RSA DECISION LOG RESPONSE

Report Title	Kingsley Avenue, Crosland, Kirklees – Stage 1 Road Safety Audit
Date:	05/03/2026
Document reference:	2329RSA1-26
Prepared by:	Leigh Ogden
On behalf of:	Kirklees Council
AUTHORISATION SHEET	
Project:	Kingsley Avenue, Huddersfield – Residential Scheme
Report title:	Decision Log – Kingsley Avenue, Huddersfield, Stage 1 Road Safety Audit
PREPARED BY:	
Name:	Leigh Ogden
Position:	Director
Signed:	
Organisation:	Paragon Highways
Date:	05/03/2026
APPROVED BY:	
Name:	Ryan Kinder
Position:	Principal Engineer
Signed:	
Organisation:	Kirklees Council
Date:

Overseeing Organisation:	Kirklees Council
RSA Team:	Haydn Vernals (Team Leader) & Sarah Vernals (Team Member)
Design organisation:	Paragon Highways

Title: **Proposed Foul and Surface Water Drainage Strategy**

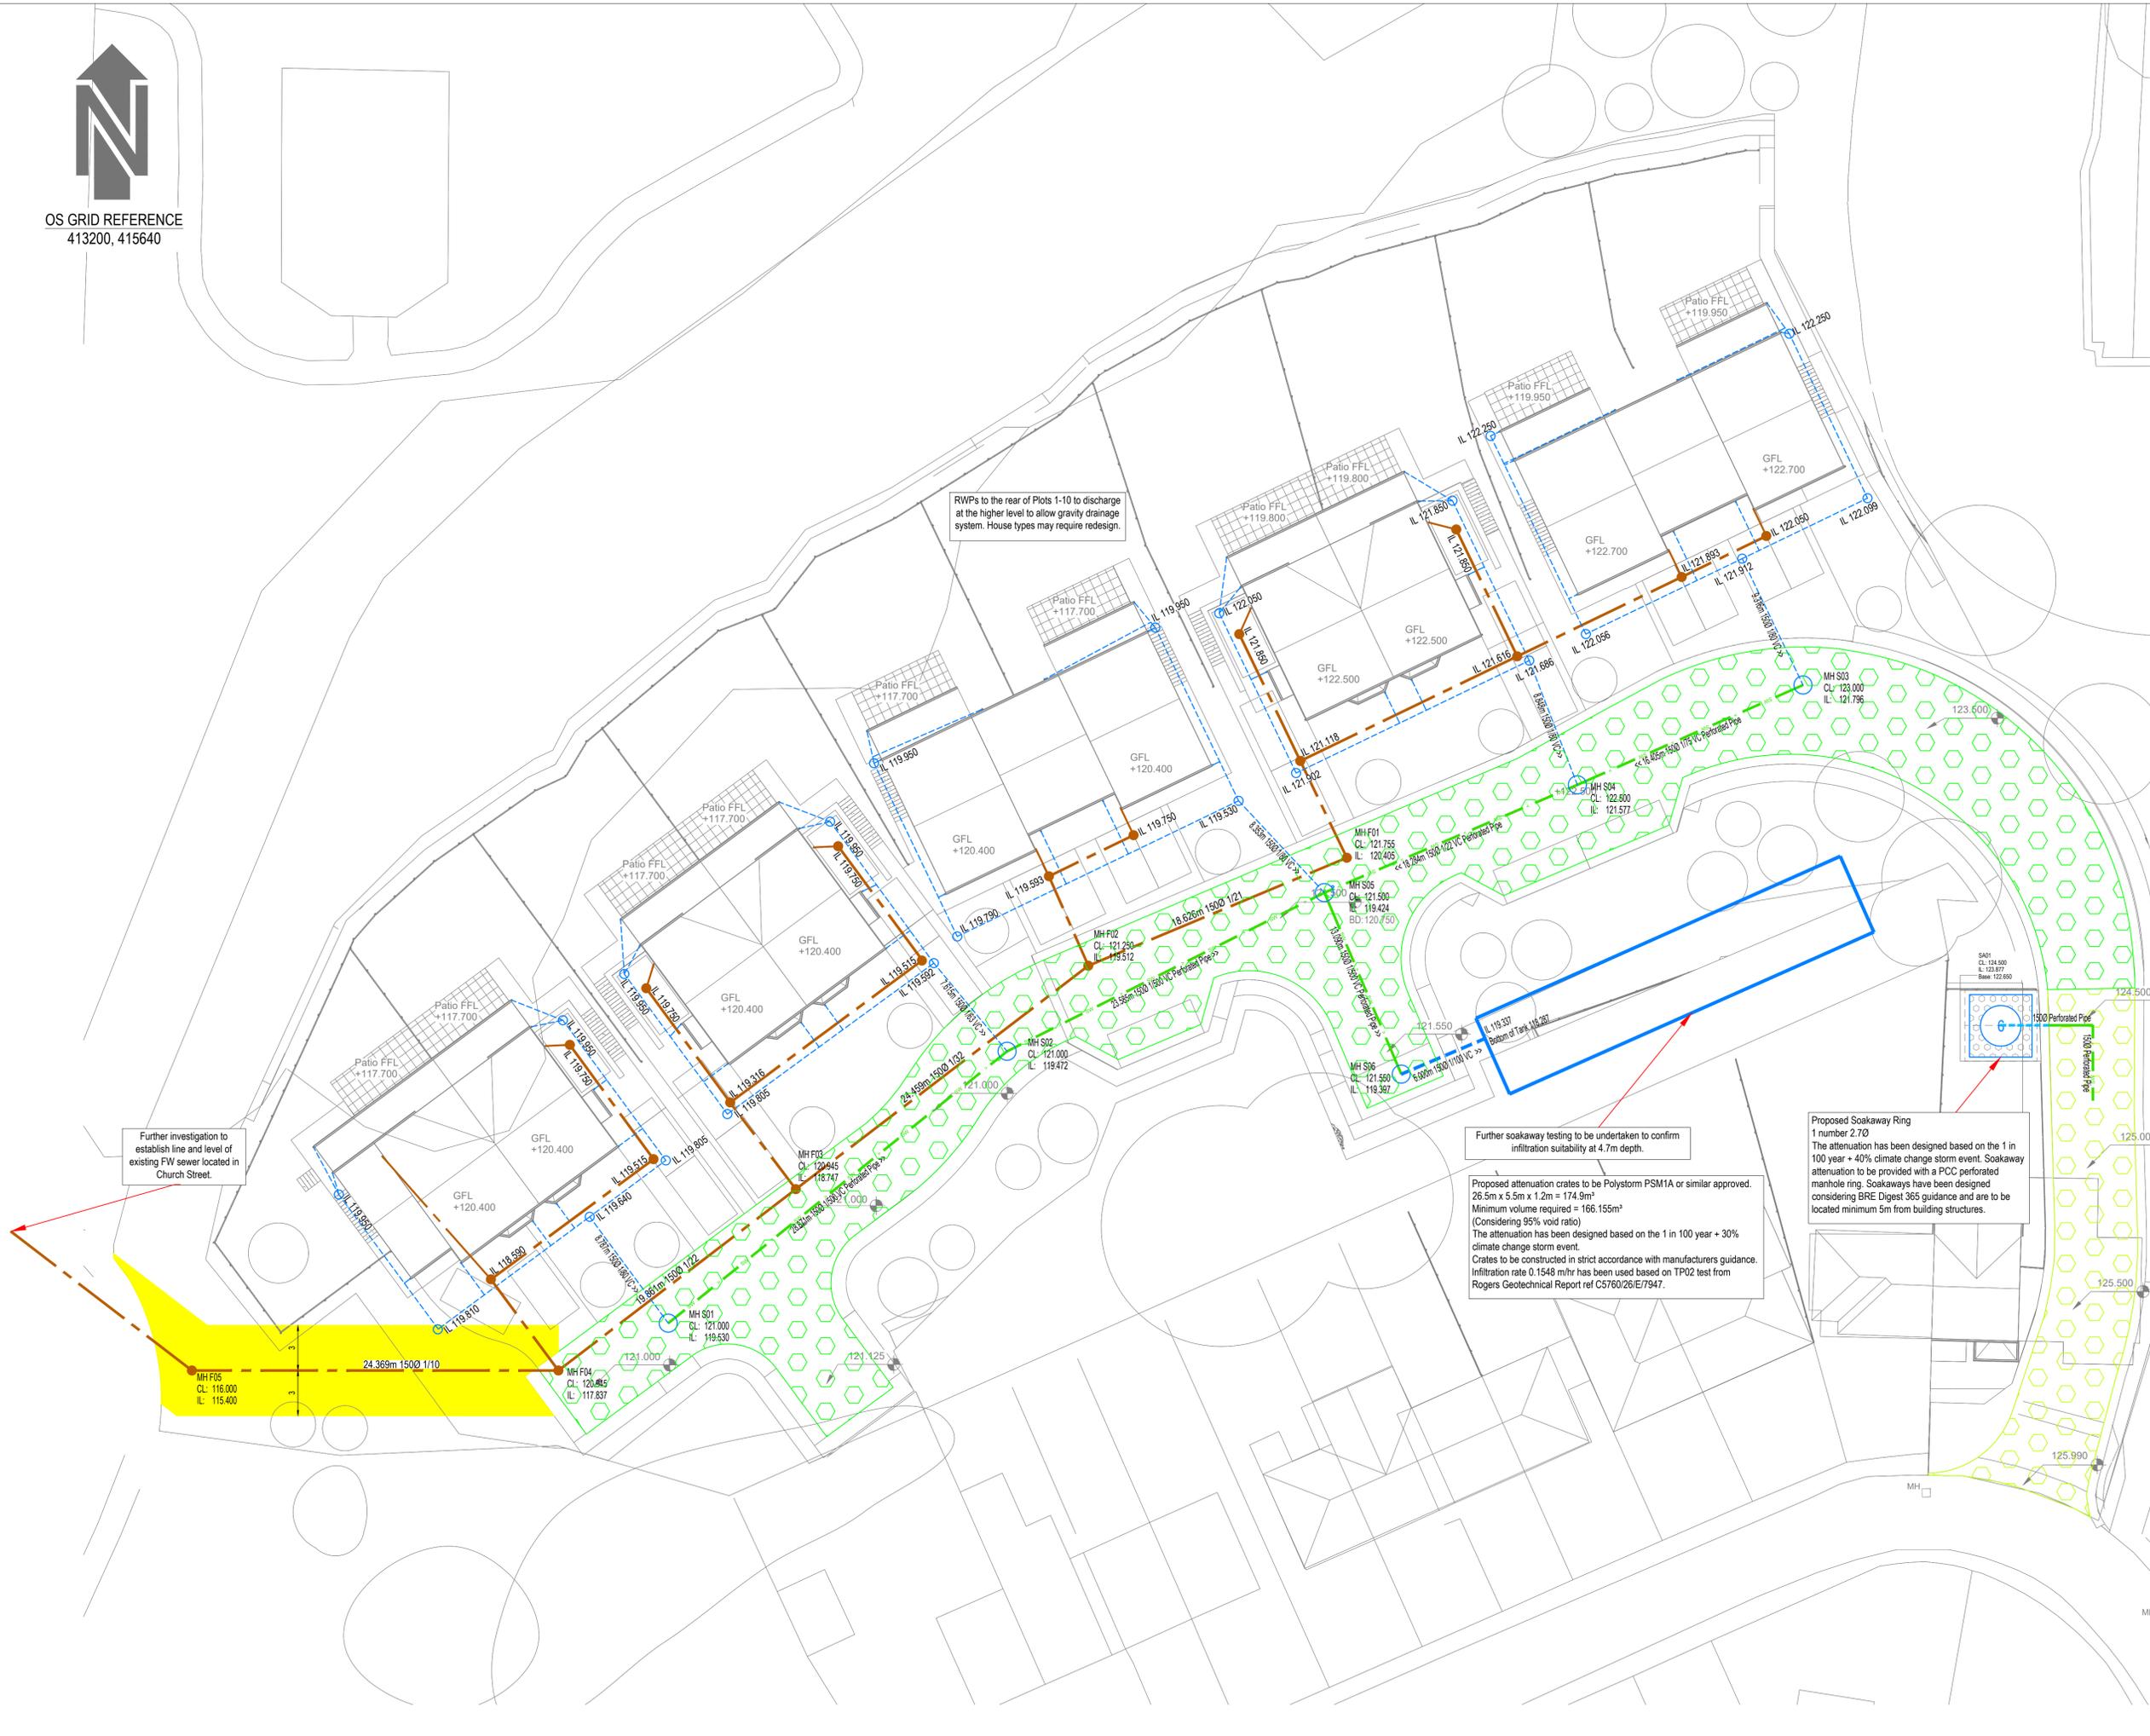
RSA problem	RSA recommendation	Design organisation response	Overseeing Organisation response	Agreed RSA action
<p>A-01 Location: Development Road</p> <p>Summary: Fences and Road Restraint Systems – Lack of barrier protection to the railway line may increase the risk of vehicle incursion onto the railway line.</p>	<p>It is recommended that the need for a barrier treatment is established and if necessary, provision proportionate to the level of risk is provided between the development road and the railway line.</p>	<p>Accepted – suitable barrier/fence shall be provided and identified at detailed design stage.</p>		
<p>A-02 Location: Development Road – Particularly outside Plots 1 & 2</p> <p>Summary: Drainage – Ineffective drainage of surface water may increase the risk skidding or loss of control type collisions</p>	<p>It is recommended that all areas are provided with suitable surface water drainage measures to minimise the risk of standing water and detritus.</p>	<p>Accepted – suitable surface water drainage shall be provided and identified at detailed design stage.</p>
